3 January 2023

RE: State Significant Development – SSD-41306367 - Proposed New Gregory Hills Public School - 28 Wallarah Circuit, Gregory Hills

Our Reference - SS/2022/2/1

Flood Planning Level

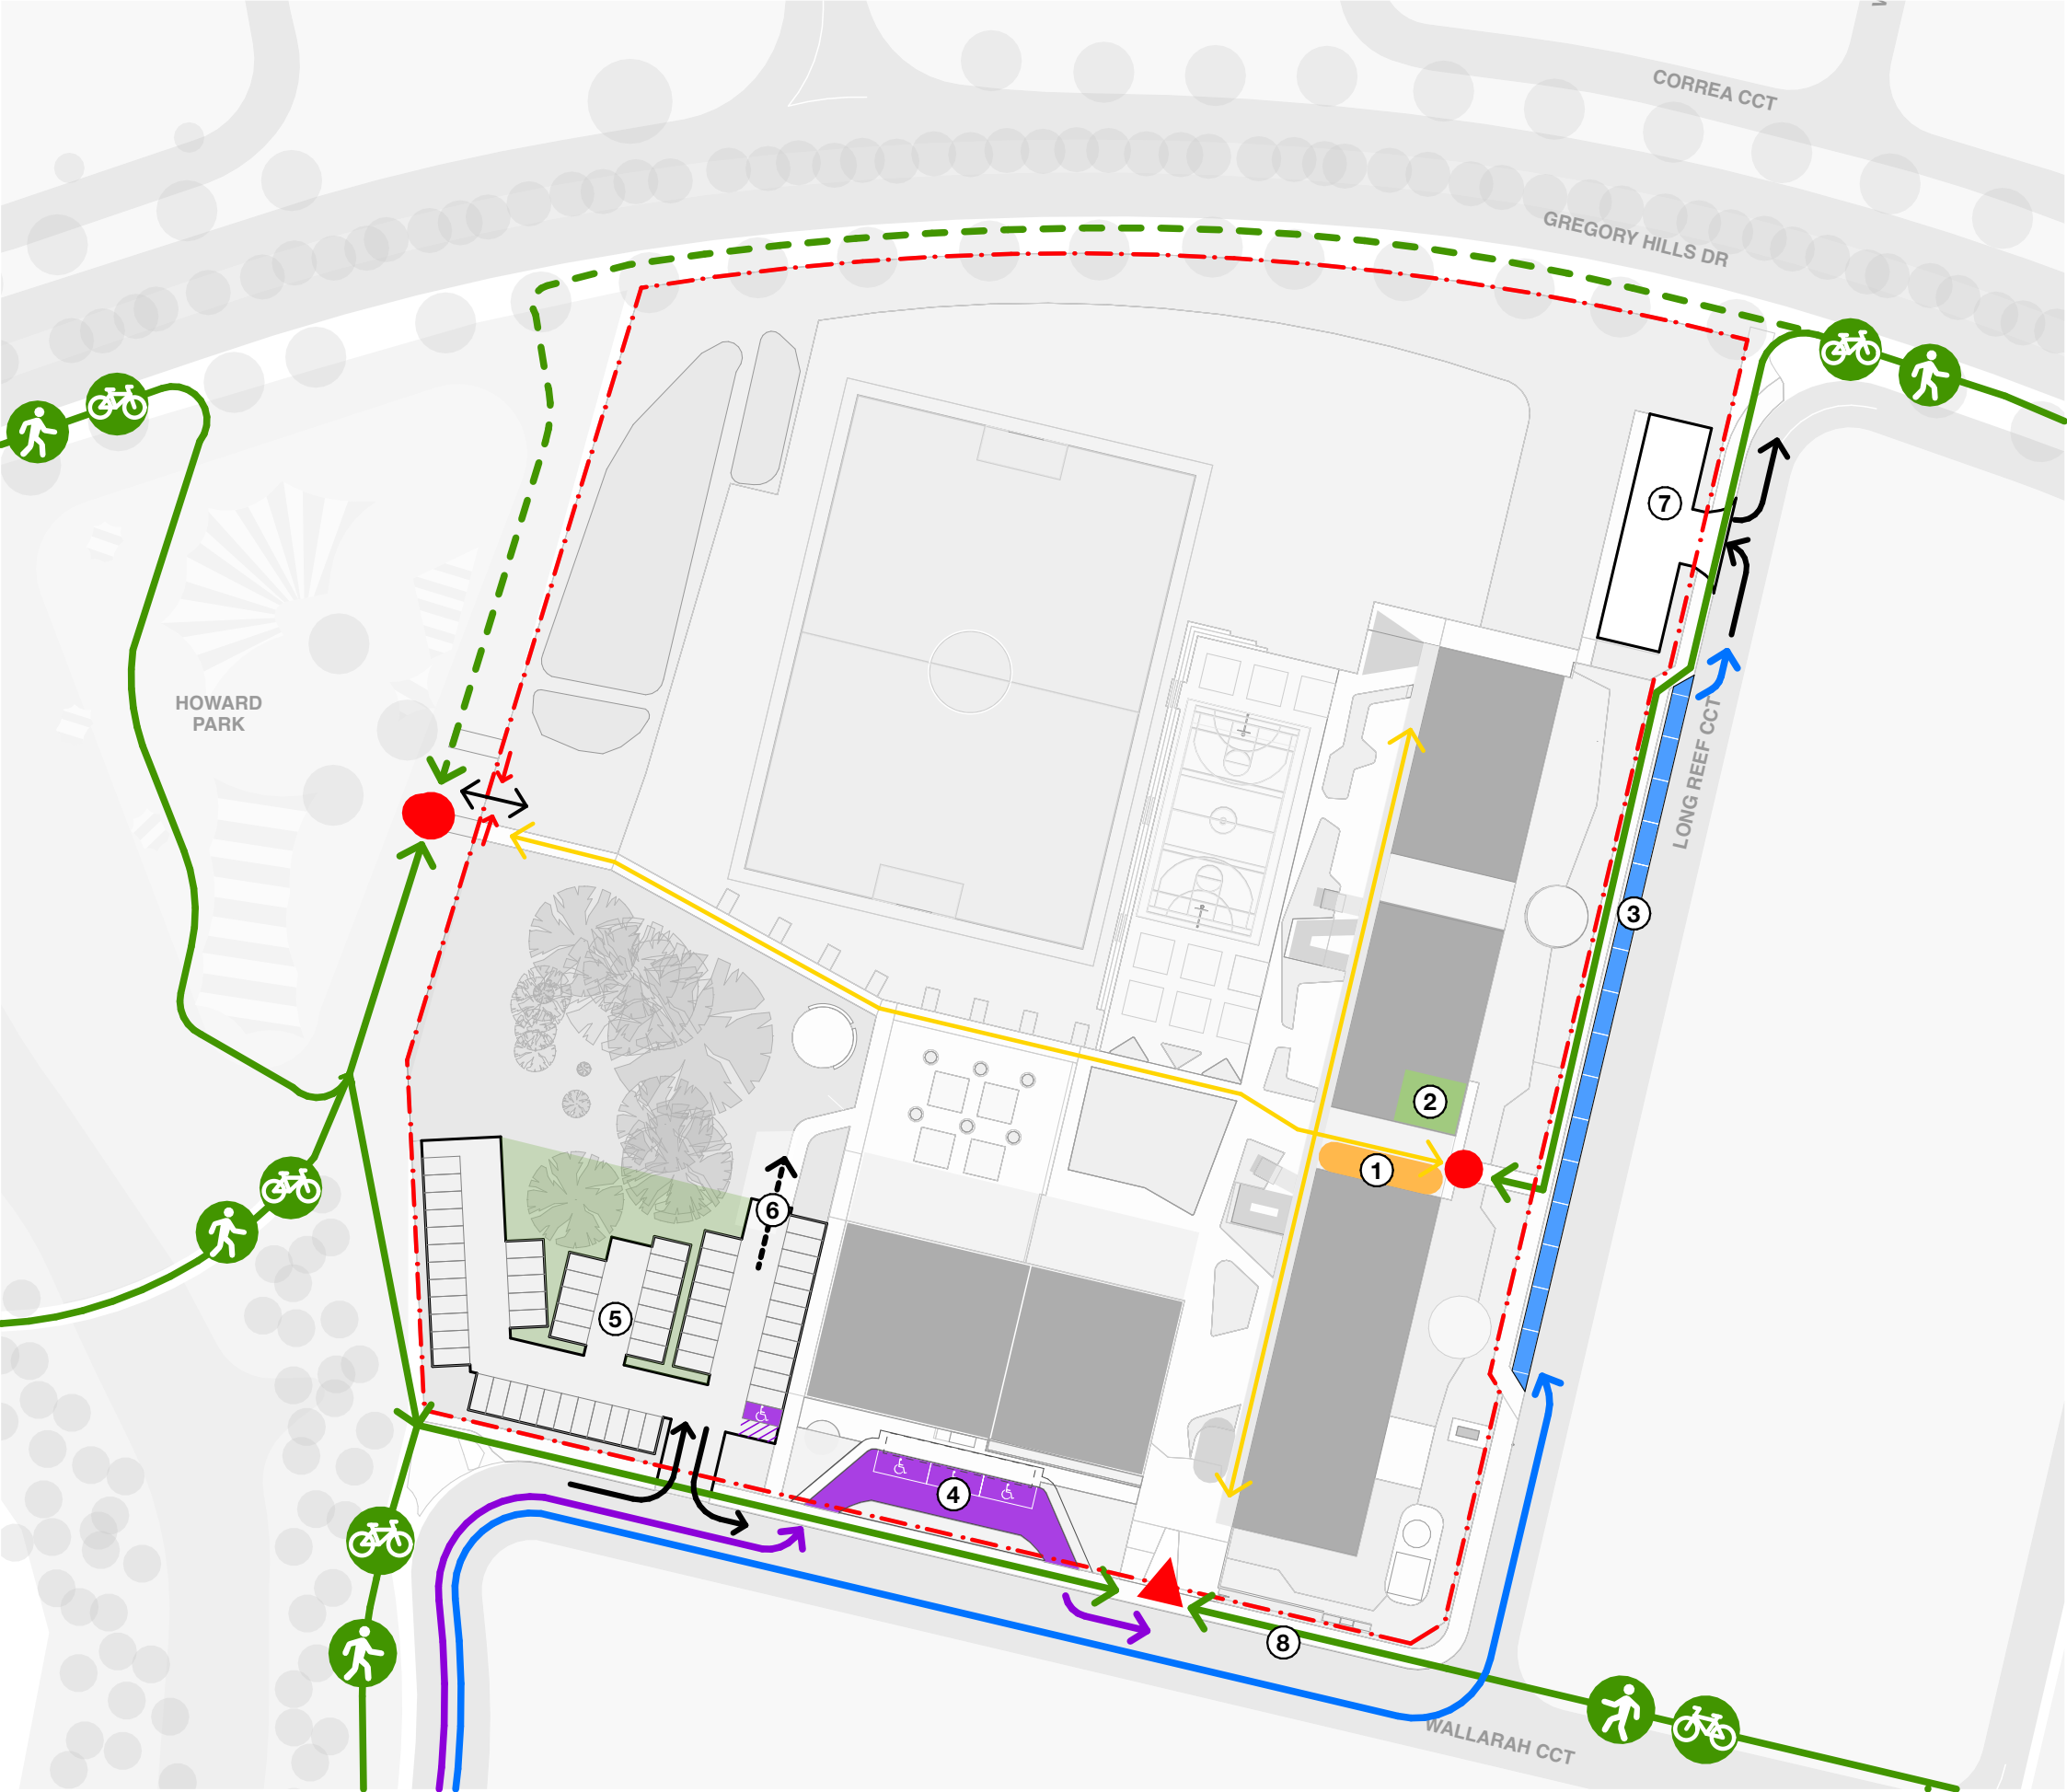
- A minor area within the site has been identified as being impacted by 1% AEP flood event. This area is limited to the north-western corner of the site with shallow depth less than 0.25 m and does not impact on the footprint of any proposed buildings. The flood planning level of the site is RL115.1m, the lowest ground floor RL (hall) is RL115.7m, the remainder have ground floor RL of 116.1m, which is consistent with the 1% AEP level plus 500mm freeboard requirement.

Proposed Parking Restrictions Option 01

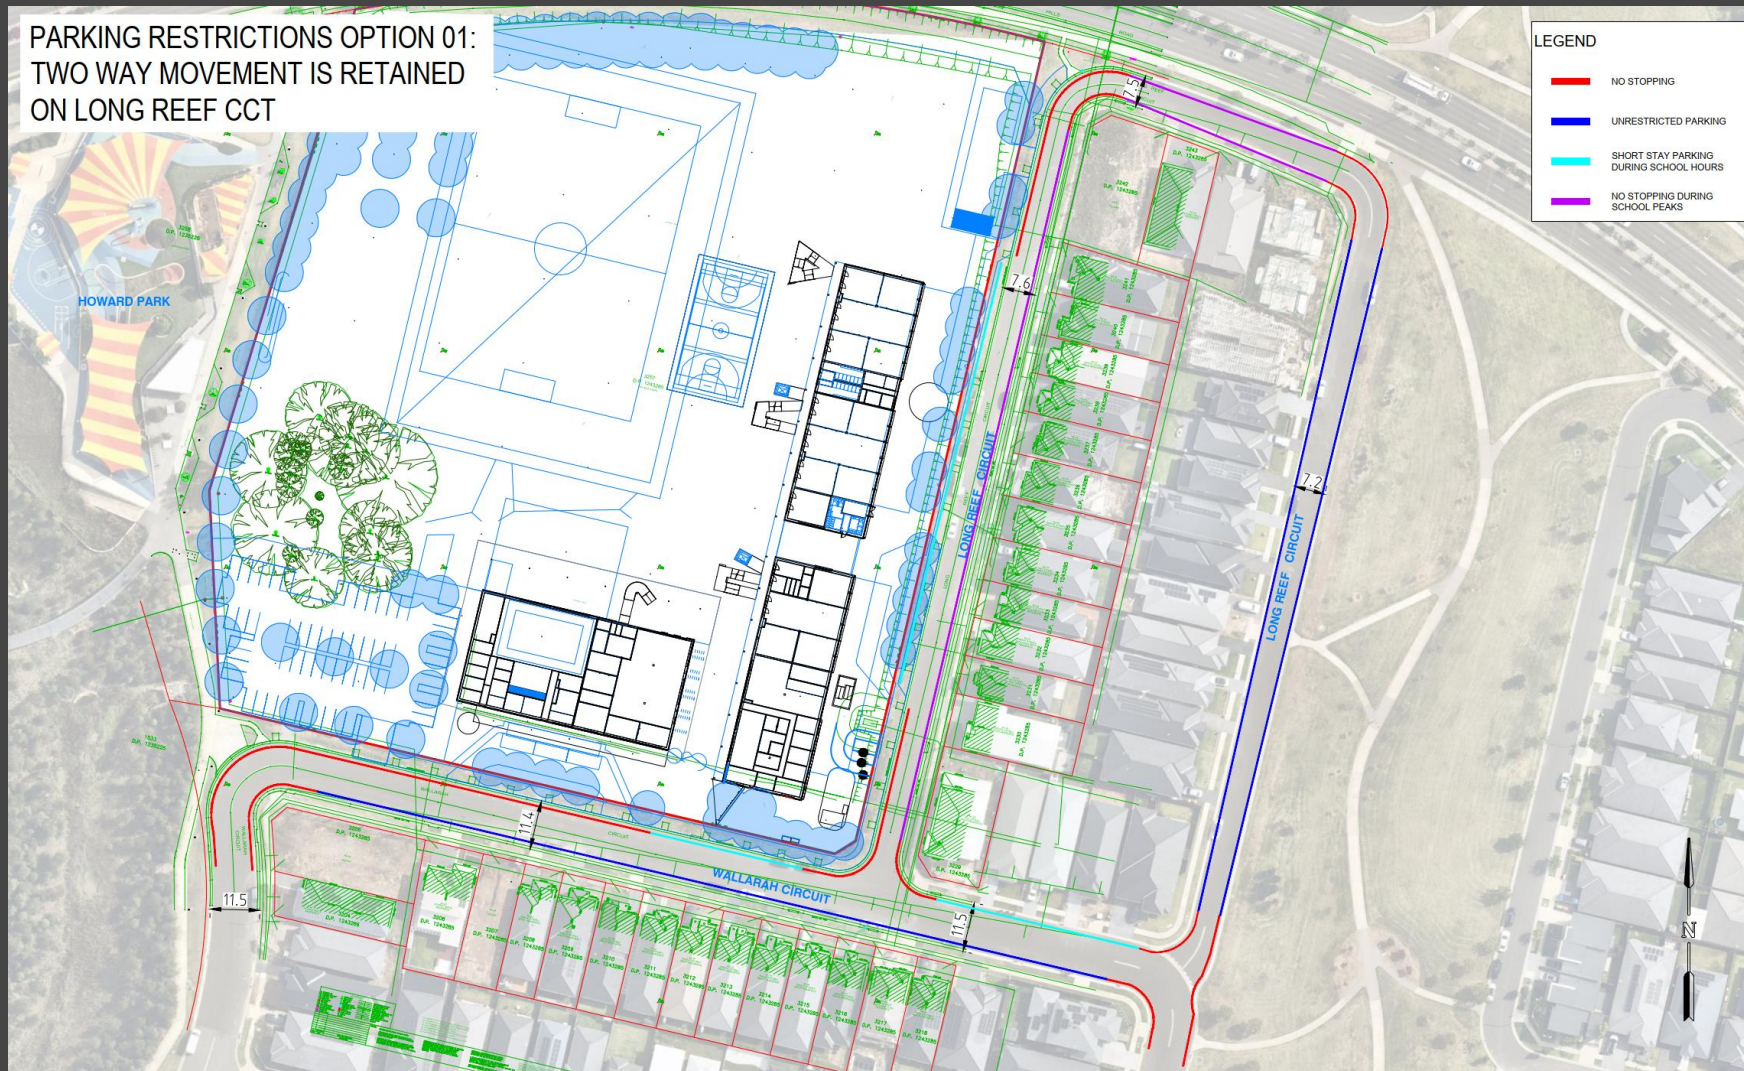
- There are no changes to the on-street parking restrictions as proposed as part of the temporary school approval recently issued by Council (DA/2022/742/1). Any changes to these parking restrictions would require the concurrence of the Local Traffic Committee, including proposed signage and line marking plans. The indented bays along Long Reef shall remain as short stay parking as indicated in the Traffic Report.

- It is recommended that indented parking be provided along the eastern side of Long Reef Circuit (along the electricity easement) rather than maintain the timed No Stopping restrictions. Indented bays would provide additional parking for parents and maintain residential amenity for occupants opposite that would not be able to utilise the eastern side of the road to park vehicles.

Proposed Pedestrian Infrastructure Option 01

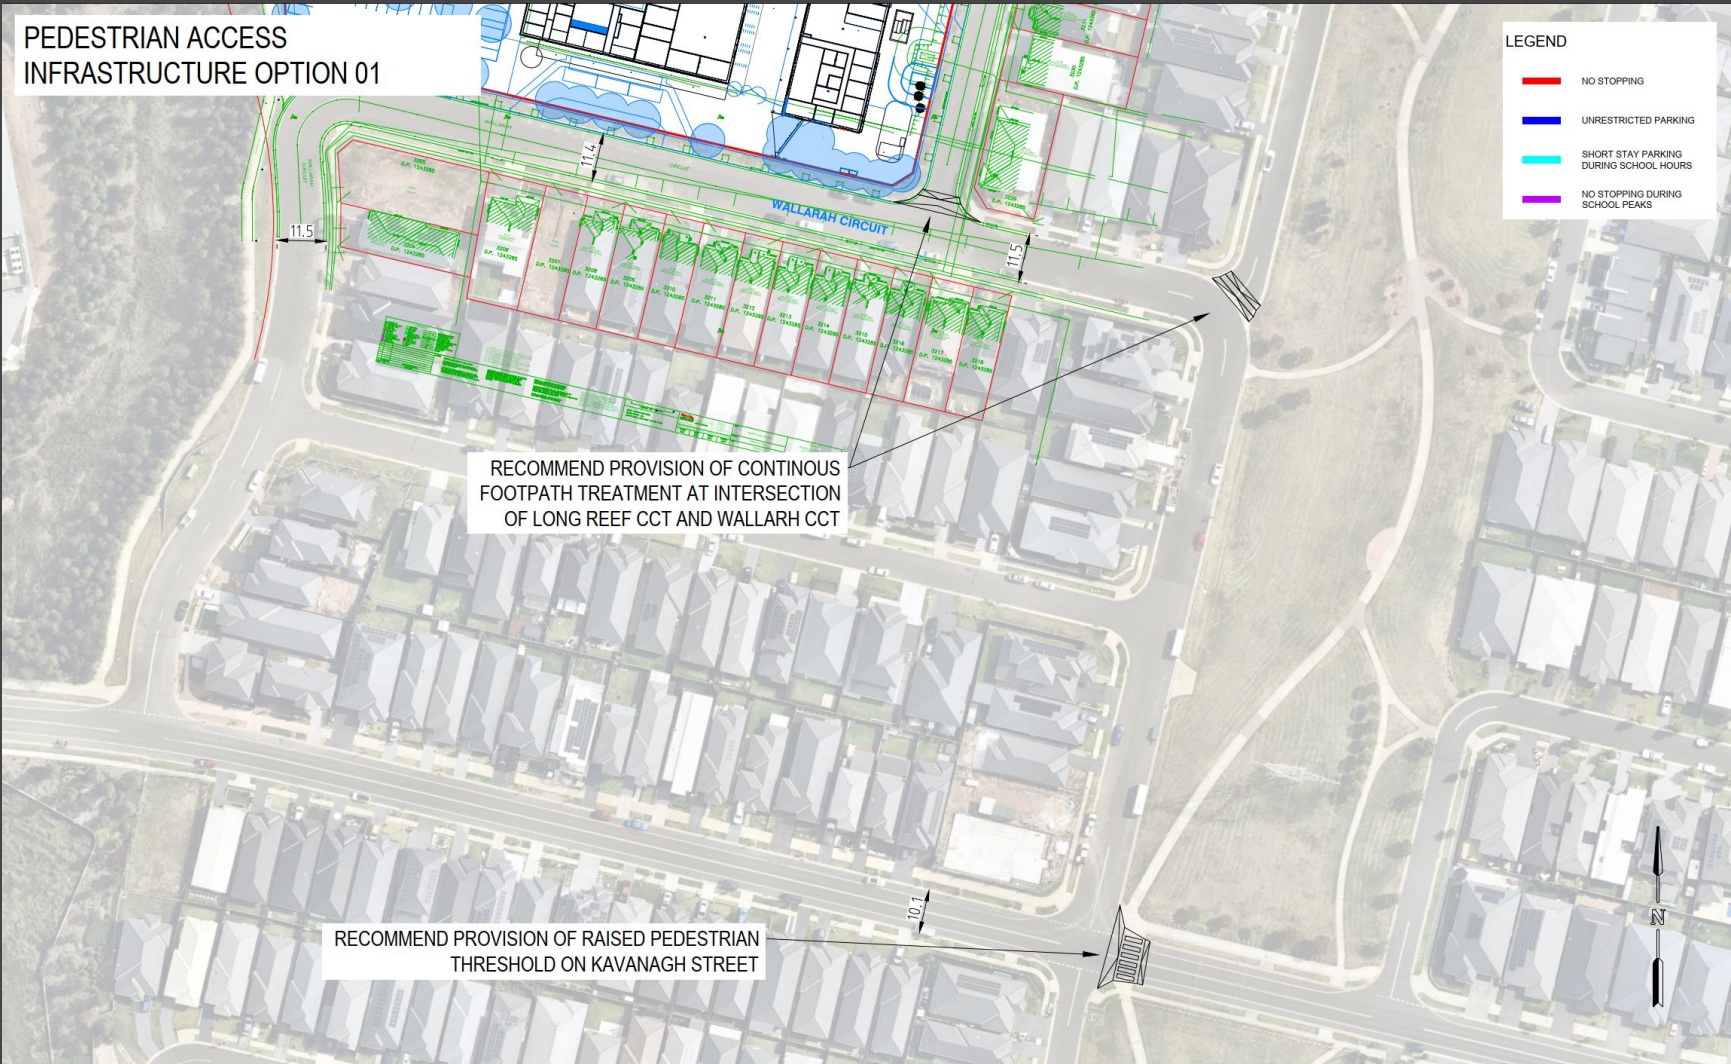
- Pedestrian refuge islands are proposed to be constructed by Council along Kavanagh Street. An installation date for these traffic facilities has not yet been confirmed. The applicant may seek to modify this proposed treatment to suit the needs of the school community.
